From: Simon Davis
Sent: 10 September 2020 10:23
To: Kate Little [REDACTED]
Cc: Sam Pinkus [REDACTED]
Subject: RE: EV Charging - Yapton

From: Kate Little [REDACTED]
Sent: 09 September 2020 17:24
To: Simon Davis <Simon.Davis@arun.gov.uk>
Cc: Sam Pinkus [REDACTED]
Subject: EV Charging - Yapton

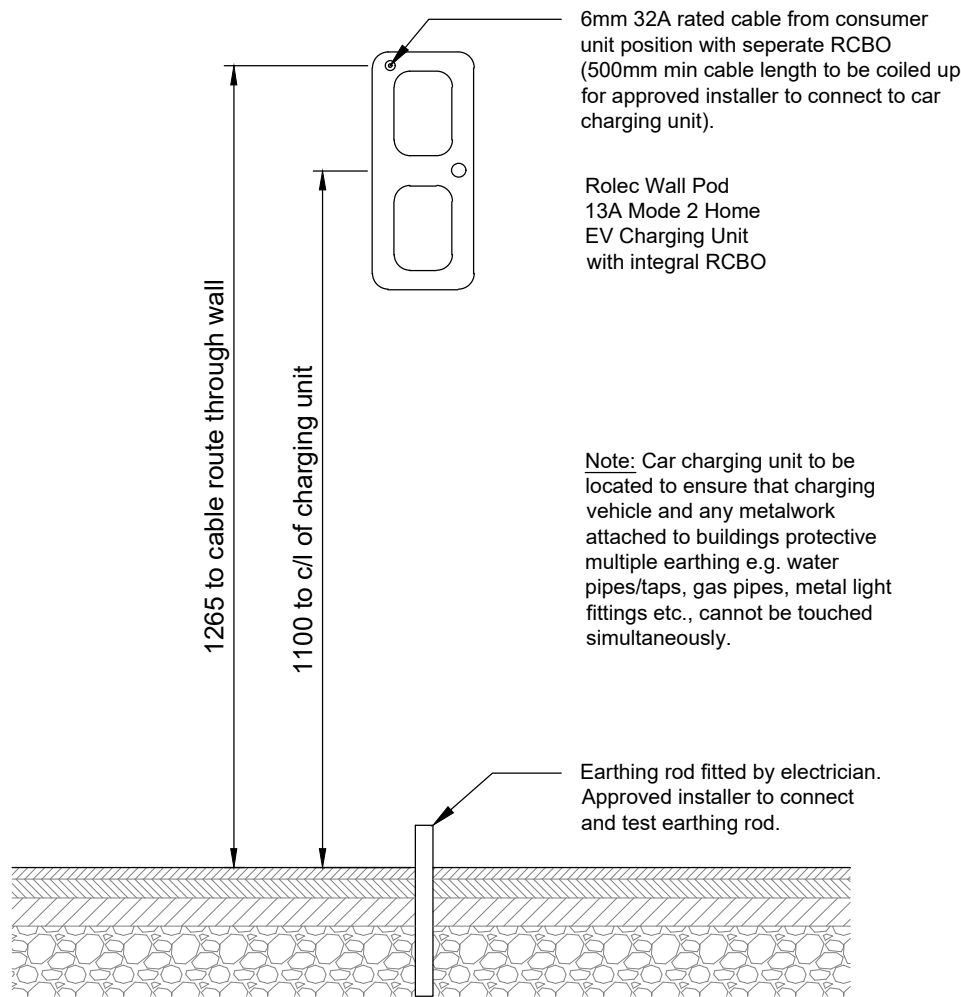
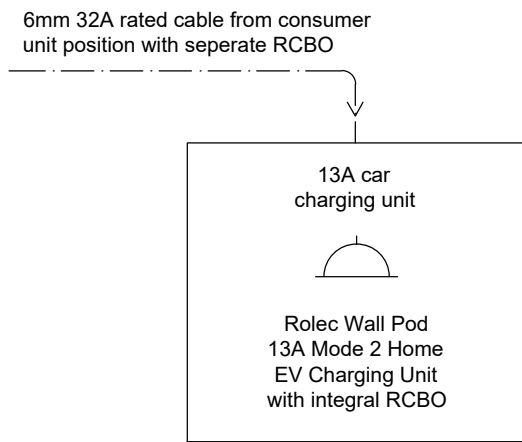
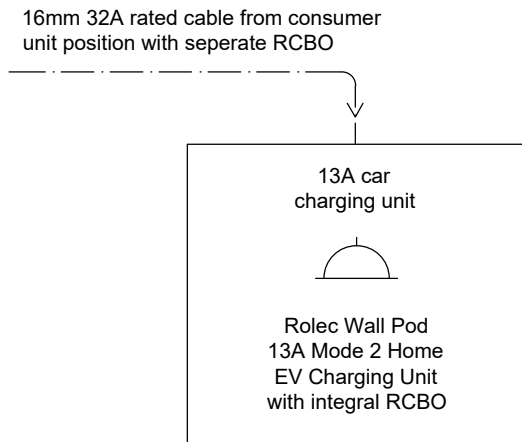
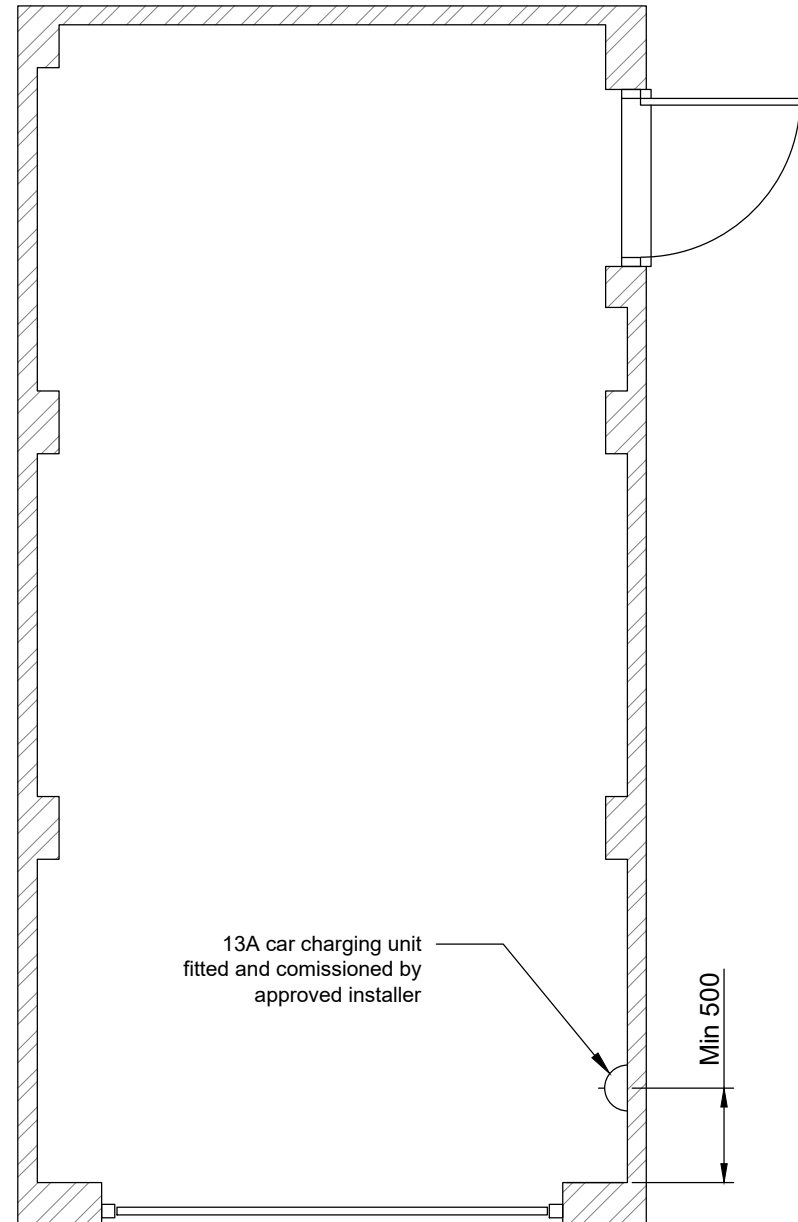
I've attached current proposals for the Yapton schemes for review, I hope this is acceptable. All but two dwellings on each site will be provided a dedicated charging point as per the attached, the point is to be within reach of all on-plot parking spaces. Could you please confirm as to whether the Council would consider these proposals acceptable? Apologies, we're slightly confused on this one!

I agree that the requirements as set out in our Parking SPD are not overly clear. In addition, there is a typo in the text in that the document states that 100% of properties with a driveway and garage require an active charge point whereas the ADC Electric Vehicle Infrastructure Study on which the EV policy was based stated "One charging point per house with garage or driveway". Our Policy team have confirmed this typo and stated that it will be fixed in due course. My understanding of the SPD is therefore that:

- 100% of parking spaces of houses with a driveway or garage require an active charge point (this reflects the correction of the typo).
- At the current rate until 2023, 20% of all other parking spaces should have an active point.
- Ducting is provided at all remaining spaces where appropriate to provide 'passive' provision for these spaces to be upgraded in future.
- Note that not all parking spaces would be defined as driveways and there is no 100% requirement for car ports.

I cannot see these plans on the file so assume they have not been submitted yet. I reaffirm that I am happy to leave this to a pre occupation style condition but if you wish you can submit these now. If so, please check over the plans as per the requirements.
